Application No: CM/24/22/PL
Site Address: Plot 9 Scyld Horsemere Green Lane Climping BN17 5QZ
Description of works: Single storey side extension. This site is in CIL Zone 3 and is Zero Rated.

Thank you for your internet representation made on 24th June 2022 which has been recorded as an objection with the comments as follows:

title:
Plot 9
Proposed Plans
status:
date:
scale:
drawn:
chk'd:

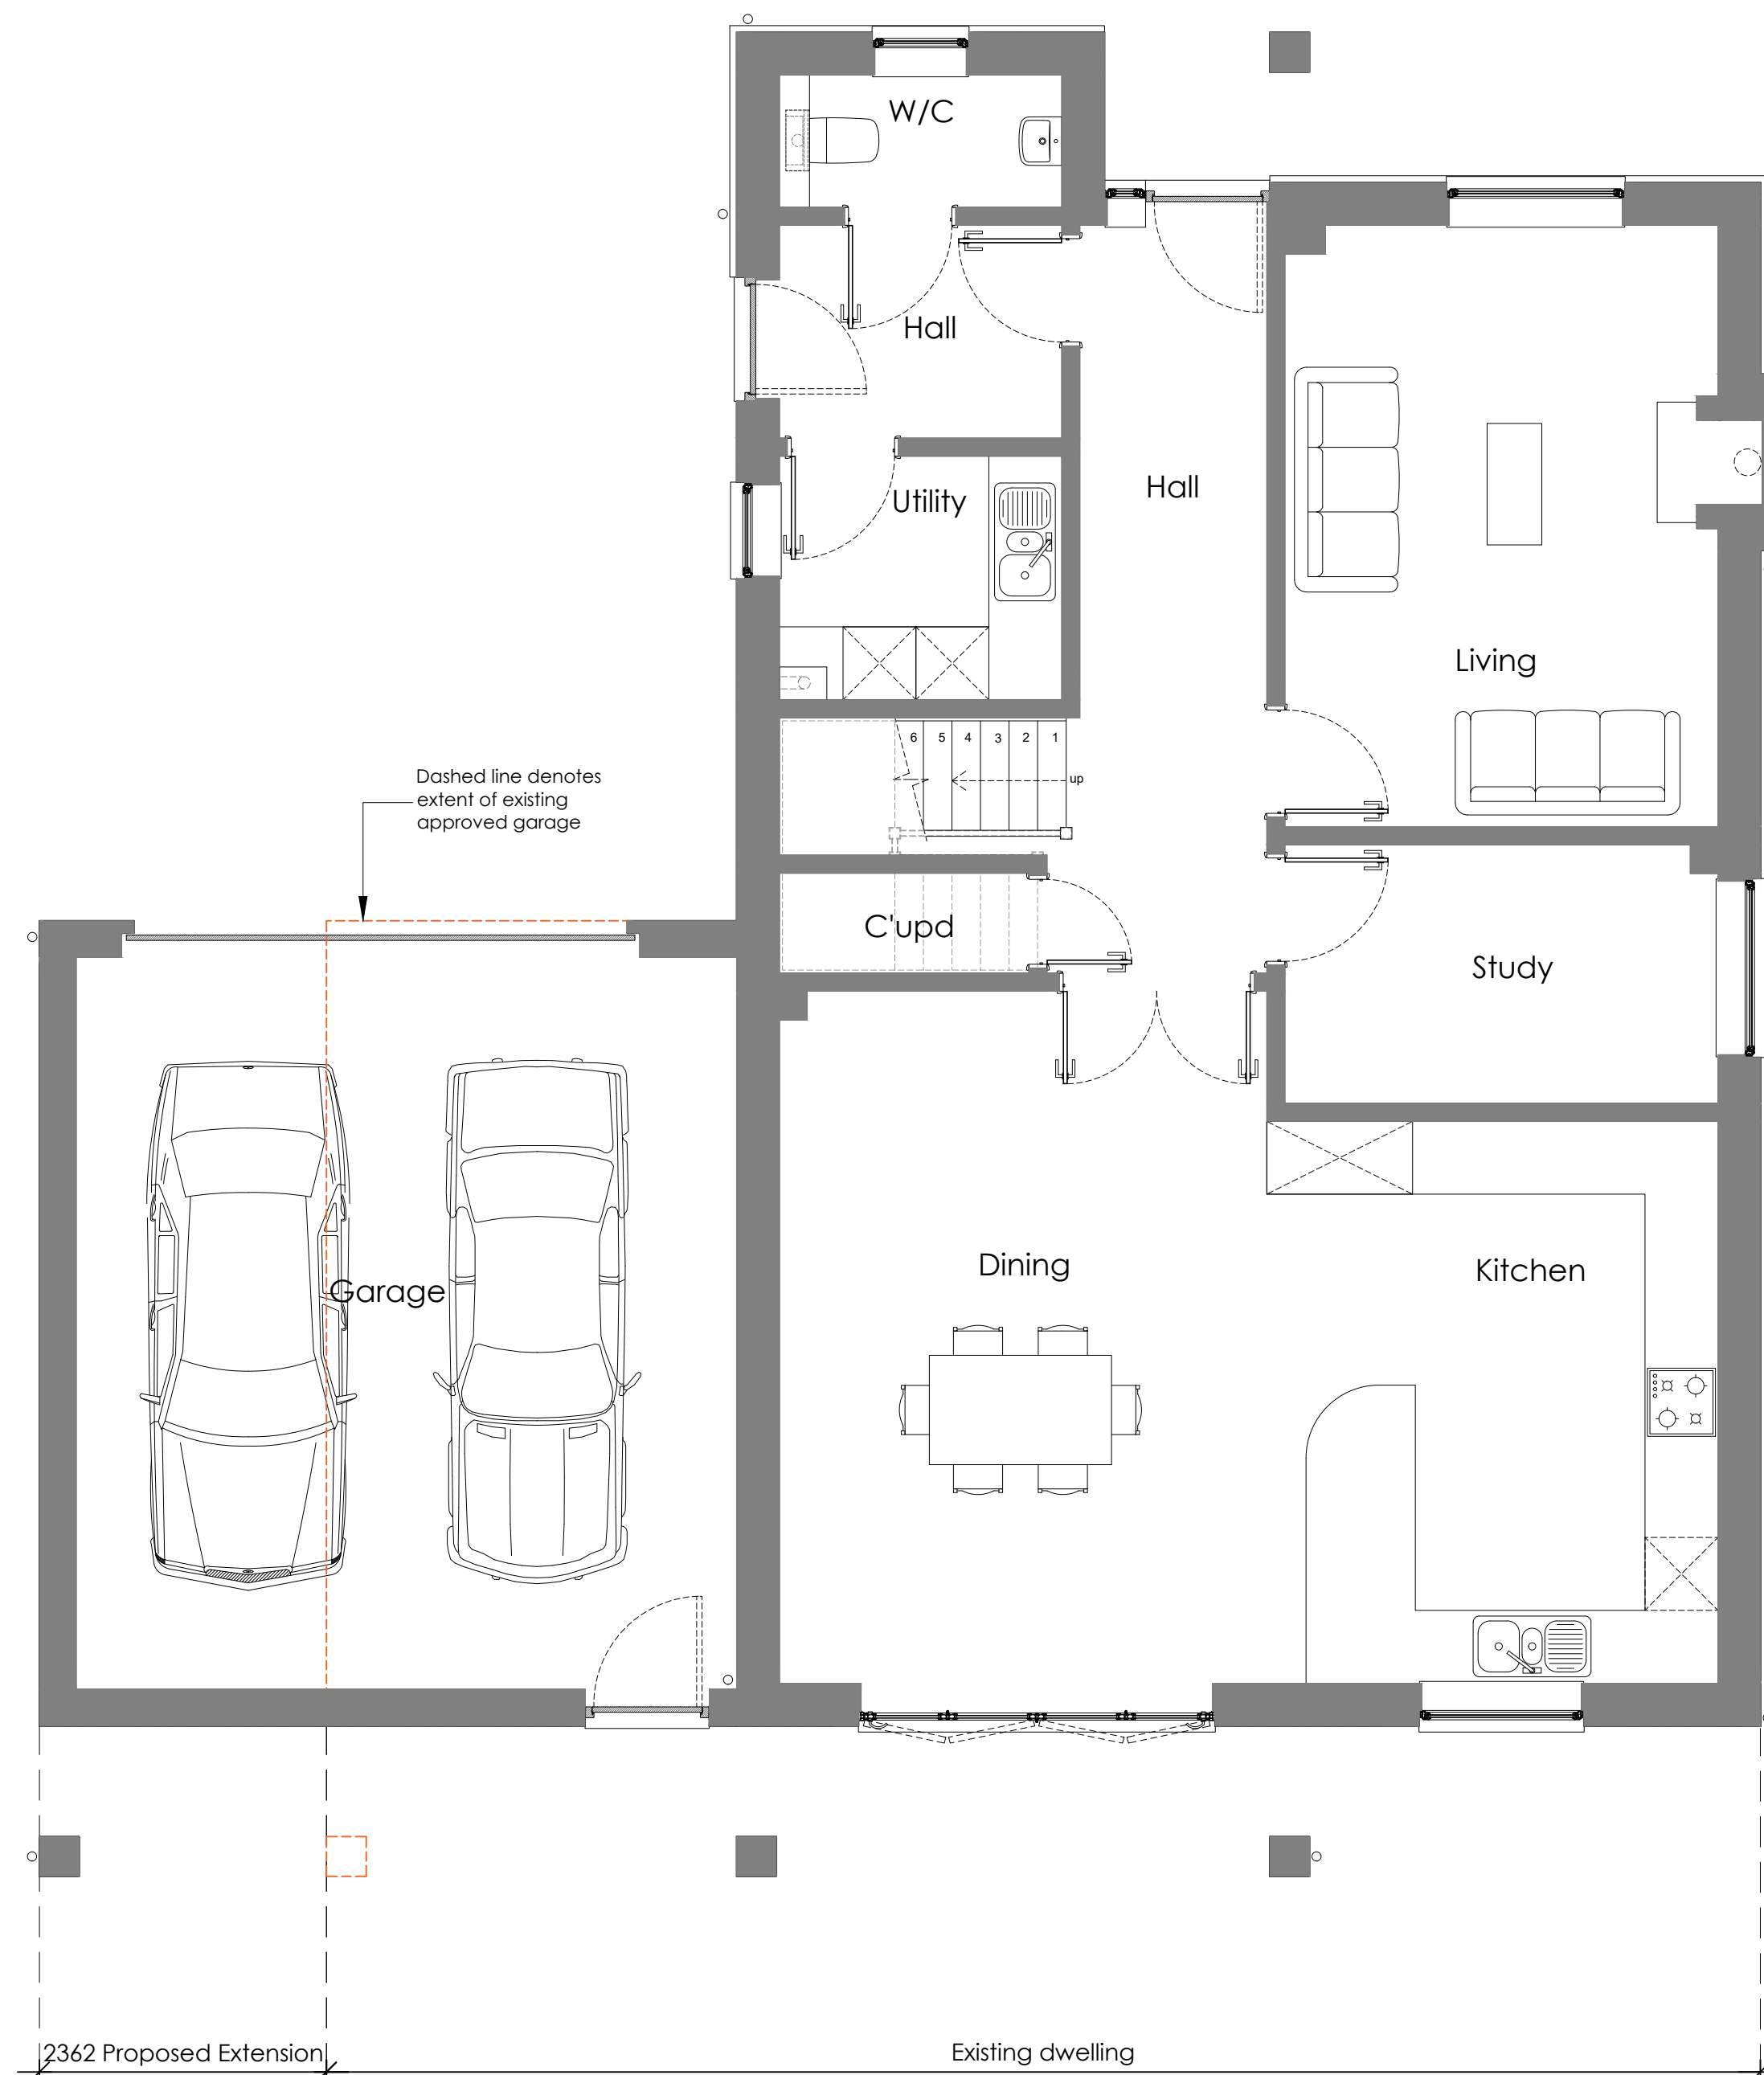
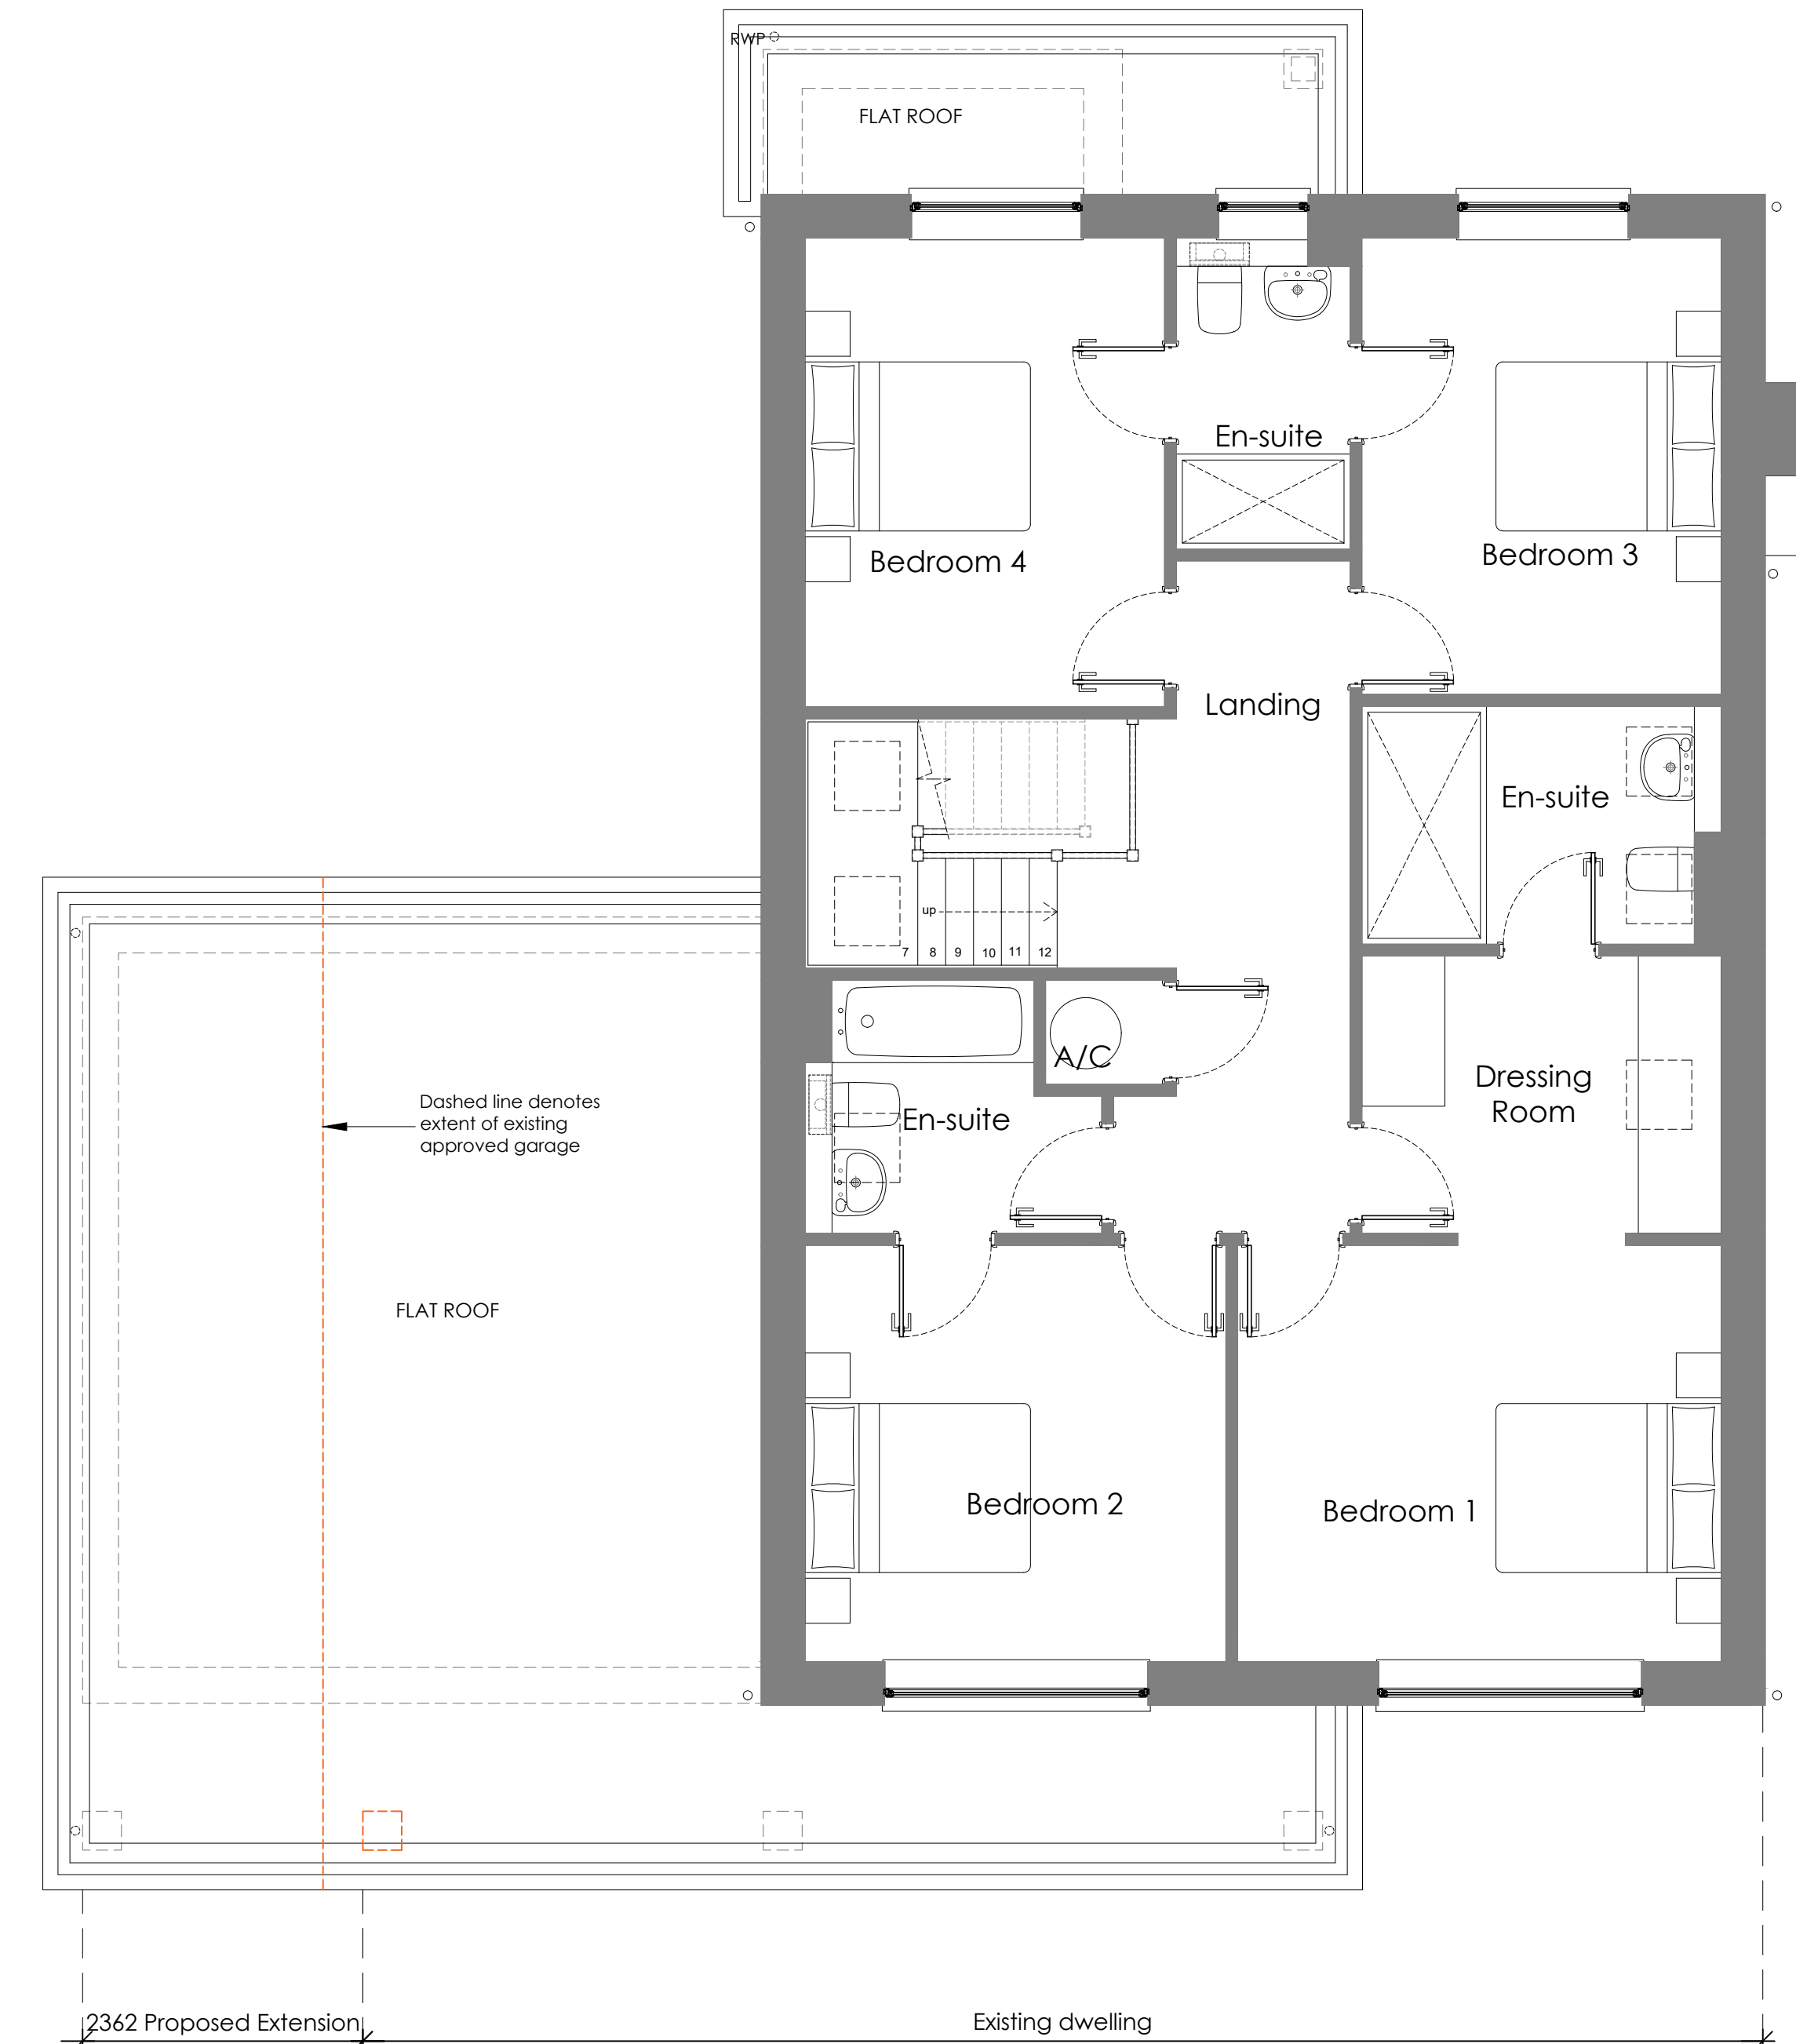
The boundary of the property/building is being brought closer to our fence, and bedroom window impacting our privacy, placing less greenery around the premises and the trees that were planned on Planting Plan 2 of 2 Dwg No 2248-TF-00-00-DR-L-3002 seem to have been lost?

Moving forward should this be approved. . once the foundations are dug, there will be the matter of the building being even closer to our boundary and bedroom window than the initial proposal that went through which changes the visual amenity to that of the rest of the development, and that of the plans next to our property which is unsatisfactory, it means people will be walking past our bedroom in a closer proximity than

We feel bad opposing this as it is not our wish to hinder the new neighbours opportunity to have a double garage, but perhaps an alternative solution that we would not oppose would be to have a double garage in a single line layout, i.e. placing a 2nd part of the garage behind the existing one? Making it longer. This would not change the visual amenity, will not reduce the space between properties, will not place hazardous goods (fuel) closer to our property, will not hinder our privacy as much as it will be the same point of access as there is at present. This would not bring the building and foundations closer to our premises so would reduce any further risk of the fence posts being impacted.
